SECTION 2: Pre-Application Meeting Worksheet

| FOR STAFF USE ONLY | |
|--|-------------------|
| DATE OF PRE-APPLICATION MEETING: 10/21/15 | TIME: 9:00 AM |

| Use or Occupancy Type(s): <u>POSSIBLE E, B & A</u> | | | | | | |

SITE PLAN

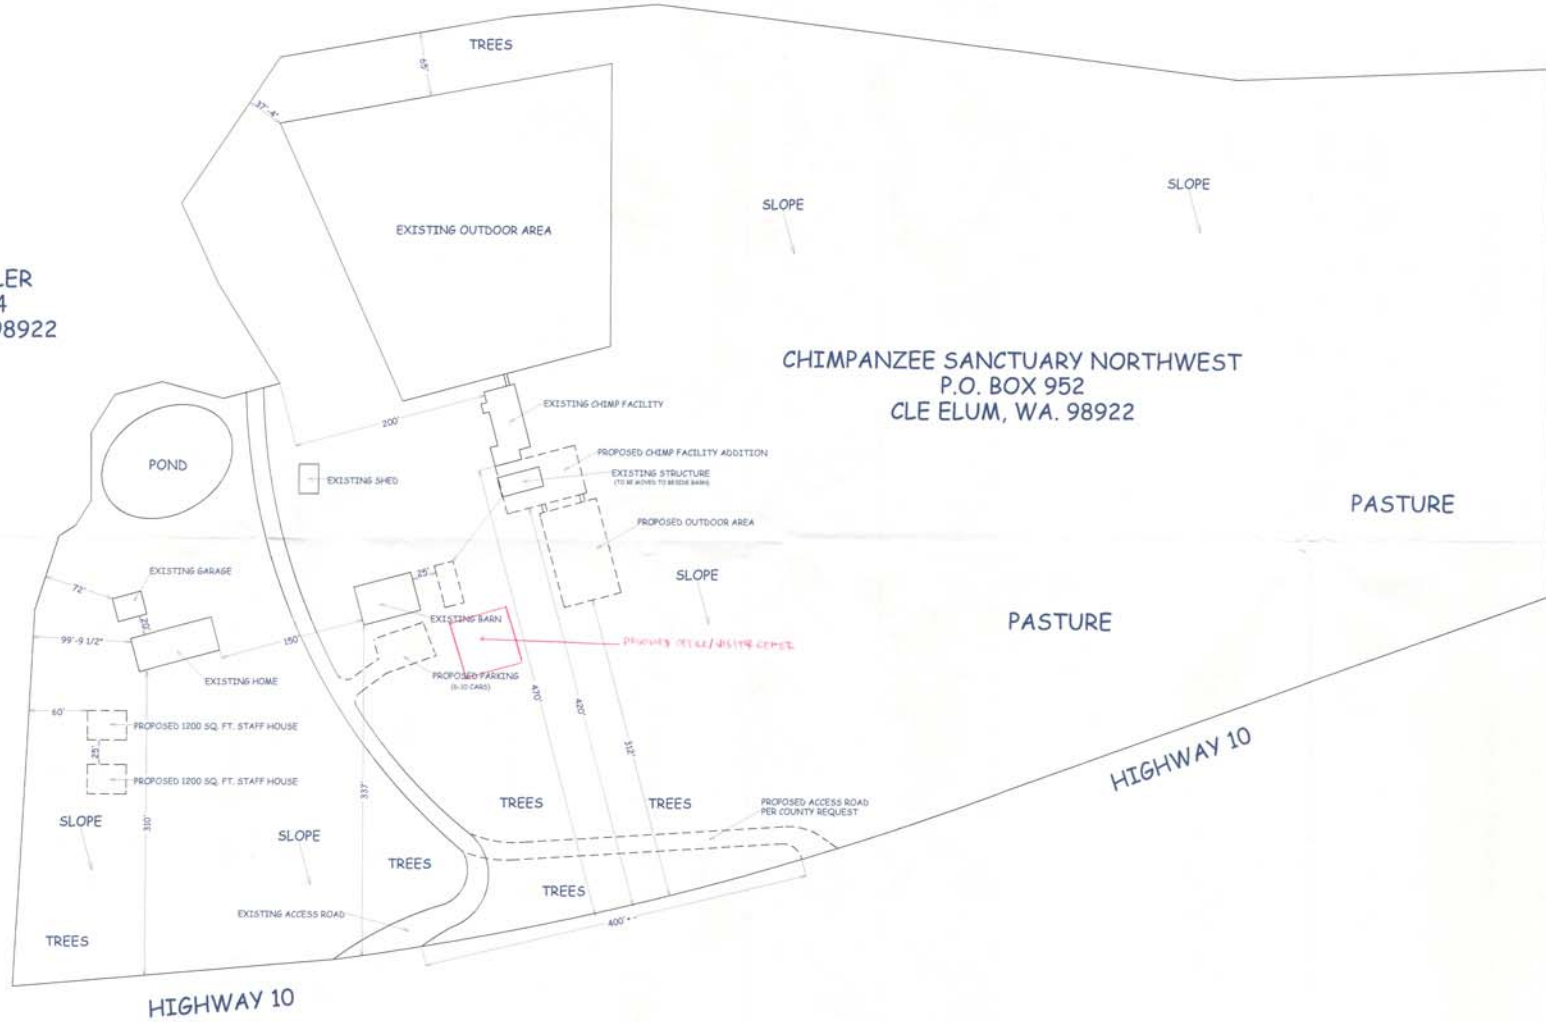
| Comments: <u>ALL BUILDINGS & STRUCTURES WILL REQUIRE FULL ENGINEERING FOR LATERAL GRAVITY & FIRE LIFE-SAFETY. ACCESSIBLE FACILITIES - RESTROOMS PARKING & MEETING.</u> | | | | | | |

| Comments: <u>more information is needed from Applicant to determine the exact process. Staff believes that a Conditional Use Permit would be required prior to expansion.</u> | | | |

Comments: *Must ~~have~~ ^{have} adequate fire apparatus access, fire sprinklers required, fire alarm to be monitored, exterior siding/materials to meet wildland-urban interface requirements. Sprinklers required only in new office building*

Comments: *Fill and Grade permit required. WSDOT access approval needs to be submitted prior to building permits. Storm water plan needs to be approved by County Engineer.*

Comments: *A WFI (water facility inventory) form needs to be completed to update numbers. Current water samples will be needed. Look at current on-site sewage system to see if any changes need to be made with additional chimps population added to the ^{existing} system. HD*
